**WELWYN HATFIELD BOROUGH COUNCIL  
EXECUTIVE DIRECTOR - PLANNING, PUBLIC PROTECTION AND GOVERNANCE**

**DELEGATED APPLICATION**

**Application No:** 6/2018/1451/HOUSE  
**Location:** Just House Coopers Lane Northaw Potters Bar EN6 4NJ  
**Proposal:** Erection of first floor extension  
**Officer:** Mr Richard Sakyi

**Recommendation:** Refused

DRG. No. AR/A3/011

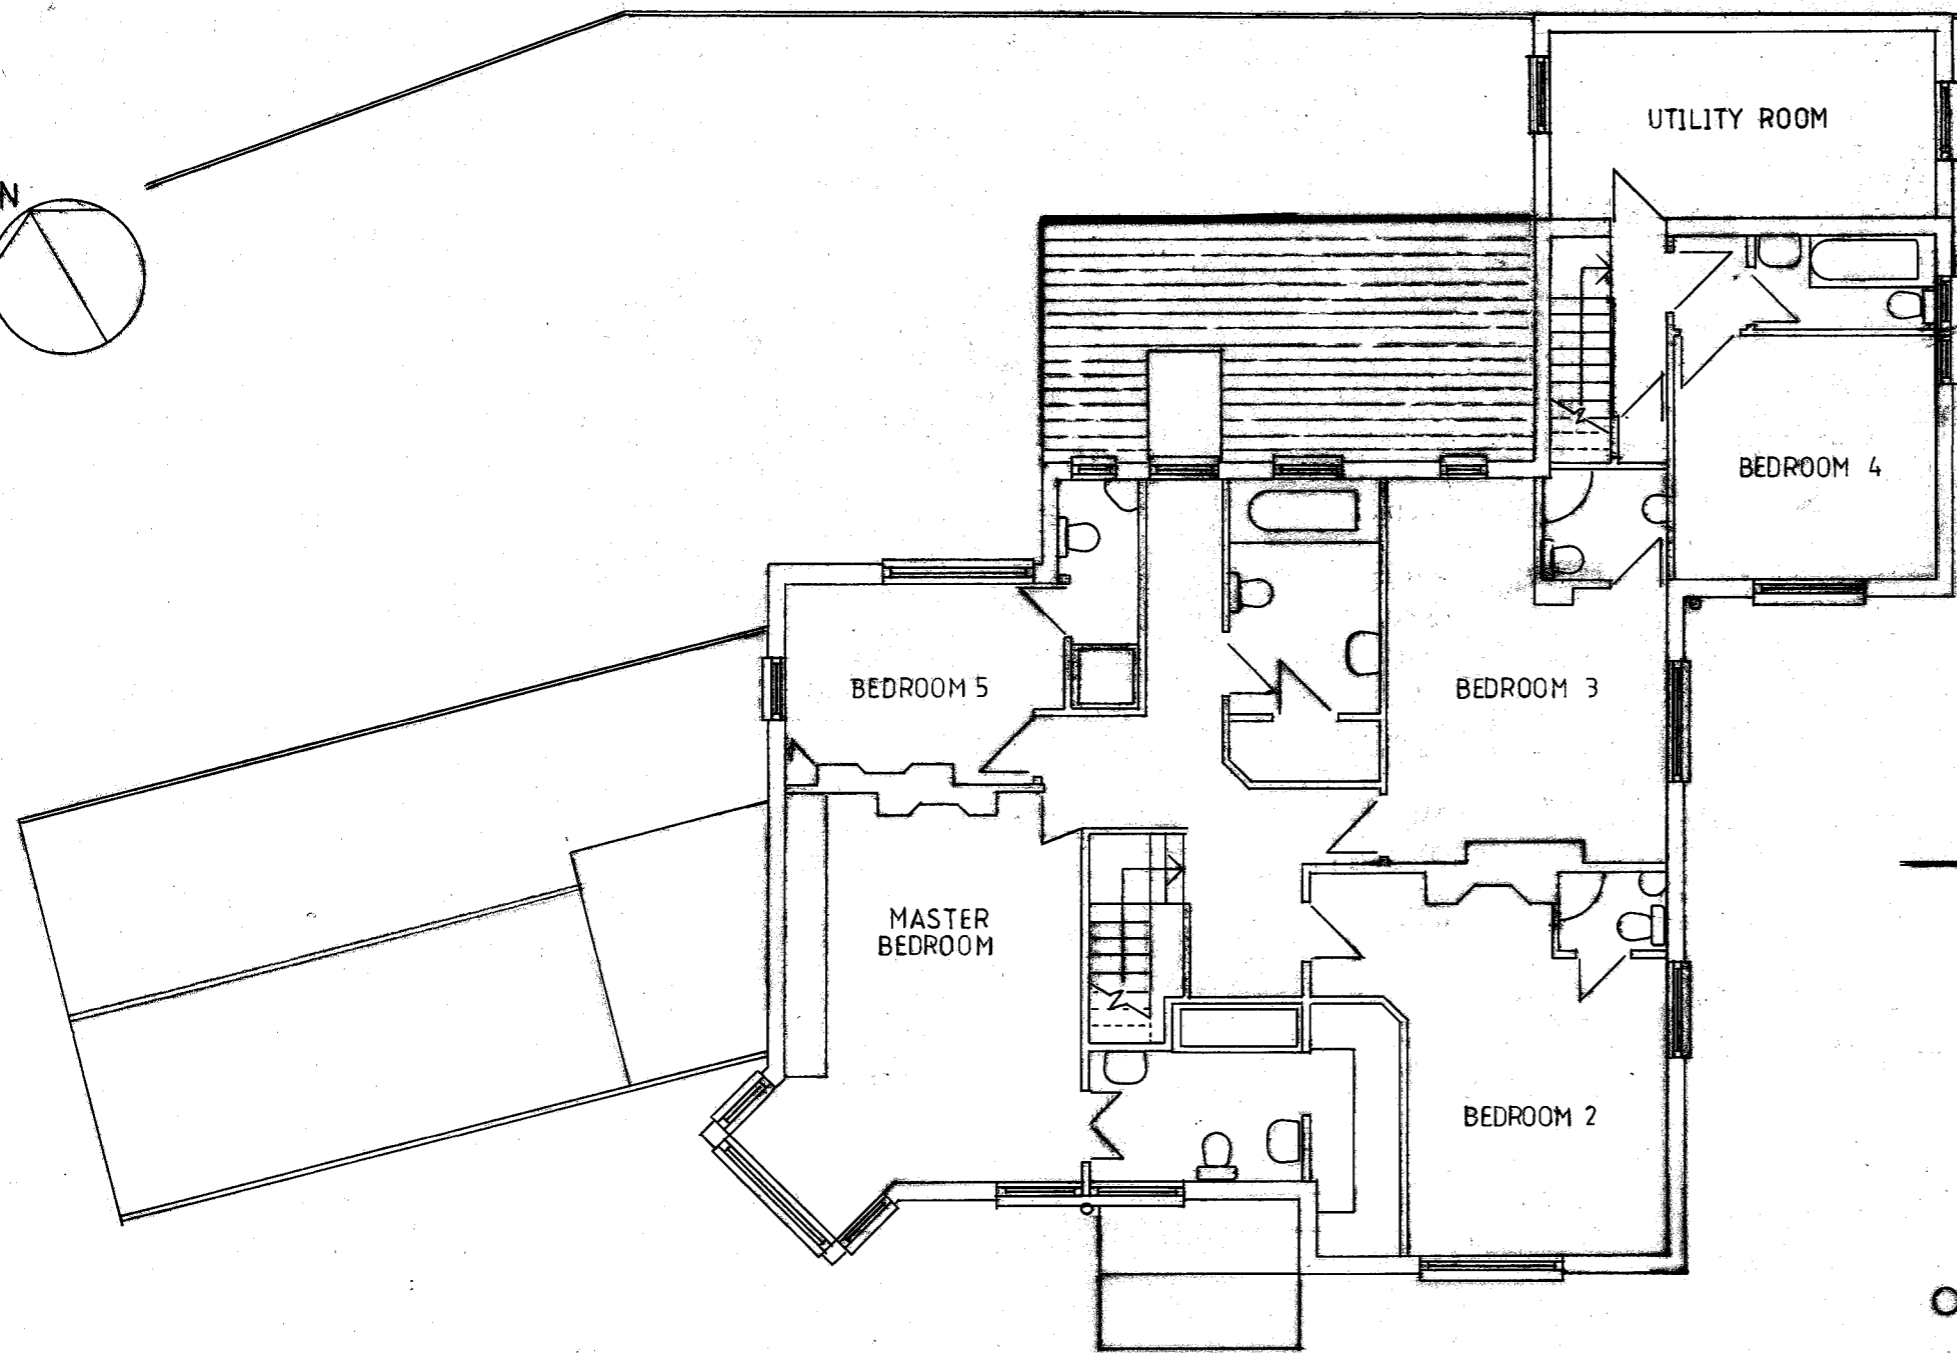
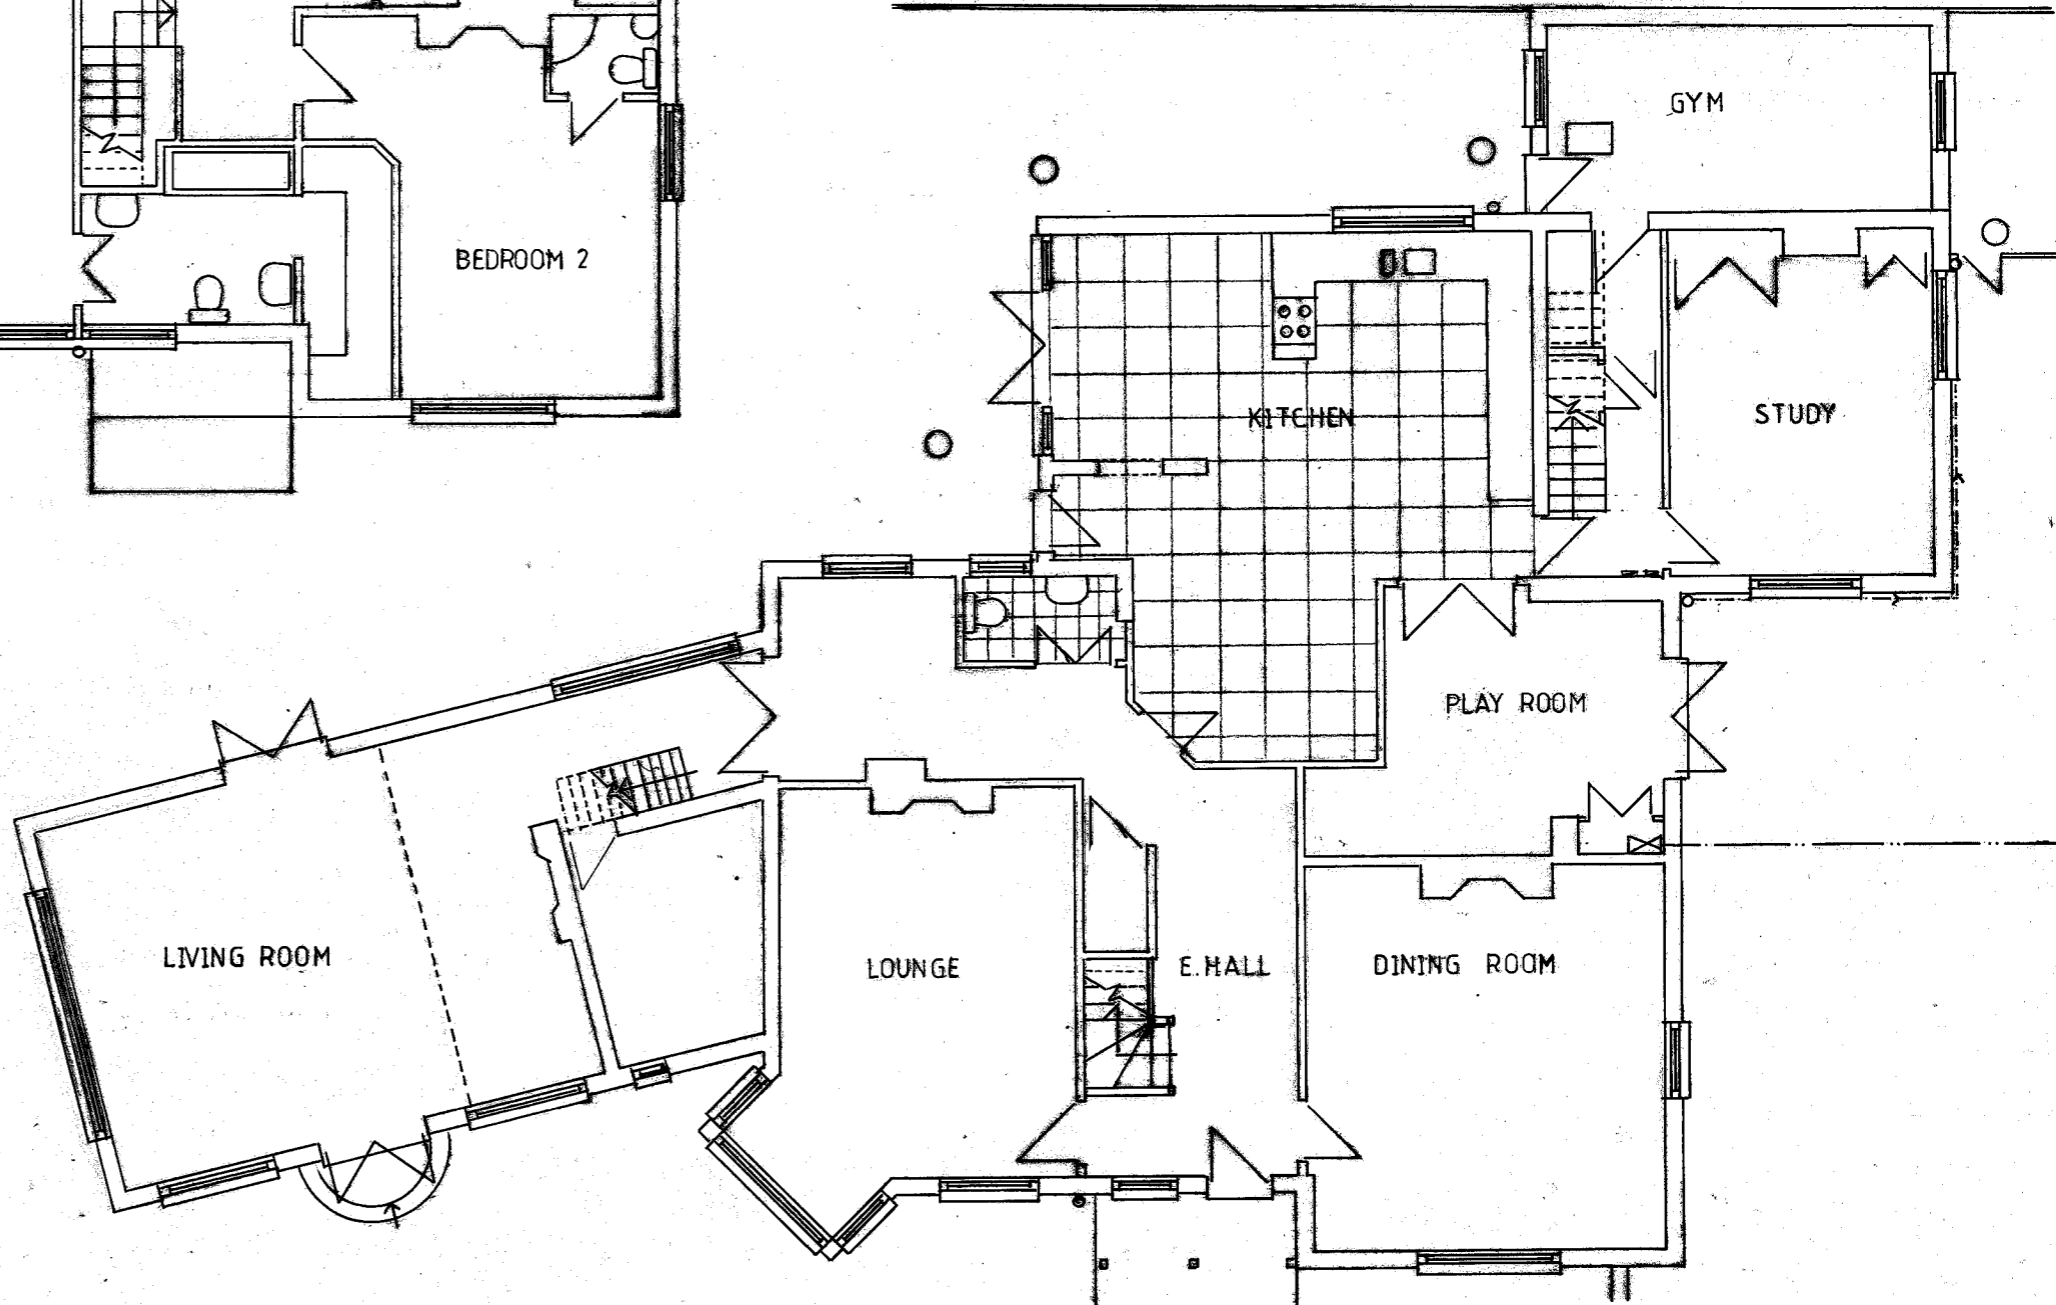
<p><b>Design (form, size, scale, siting) and Character (appearance within the street scene)</b></p>	<p>The proposed extension would result in a two storey flat roof addition to the existing dwellinghouse. The extension would be flush with the front wall of the dwelling and would be close to the northern boundary of the site and as a result would be open to public views within the street. A two-storey flat roof extension in this location is an unacceptable form of development as it would fail to complement or reflect the design of the host property. Although there is an element of flat roof on the existing building which links the two-storey section with the single-storey element, its position and form appears consistent and coherent with the architectural character of the original building. Furthermore, the two elements would not be visually read in the same context. The proposed extension would not sit comfortably with the main building and the general streetscene.</p> <p>It is considered that by virtue of siting, size, design and prominence, would form an incongruous addition which would fail to respect and relate to the design and appearance of the application property and would detract from the character and appearance of the surrounding area. Accordingly, the proposal would be of a poor quality design which is contrary to the purposes and intent of Policies GBSP2, D1 and D2 of the Welwyn Hatfield District Plan 2005, Policies SP9 and SADM11 of the Council's Emerging Local Plan 2016, the requirements of the Supplementary Design Guidance (Statement of Council Policy 2005) and the National Planning Policy Framework 2018.</p>

<b>Conclusion</b>	
<p>The proposed first floor side extension, by virtue of their siting, size and design, would form an incongruous addition to the side of the host dwelling, which would have a detrimental impact upon the character and appearance of the street scene and the host dwelling. Accordingly the proposal would be of a poor quality design which is contrary to the purposes and intent of Policies GBSP2, D1 and D2 of the Welwyn Hatfield District Plan 2005, Policies SP9 and SADM11 of the Council's Emerging Local Plan 2016, the requirements of the Supplementary Design Guidance (Statement of Council Policy 2005) and the National Planning Policy Framework 2018.</p>

1. The proposed first floor side extension, by virtue of siting, size, design and prominence, would form an incongruous addition which would fail to respect and relate to the design and appearance of the application property and would detract from the character and appearance of the surrounding area. Accordingly the proposal is of poor quality design which is contrary to Policies GBSP2, D1 and D2 of the Welwyn Hatfield District Plan 2005, Policies SP9 and SADM11 of the Council's Emerging Local Plan 2016, the requirements of the Supplementary Design Guidance (Statement of Council Policy 2005) and the National Planning Policy Framework 2018.
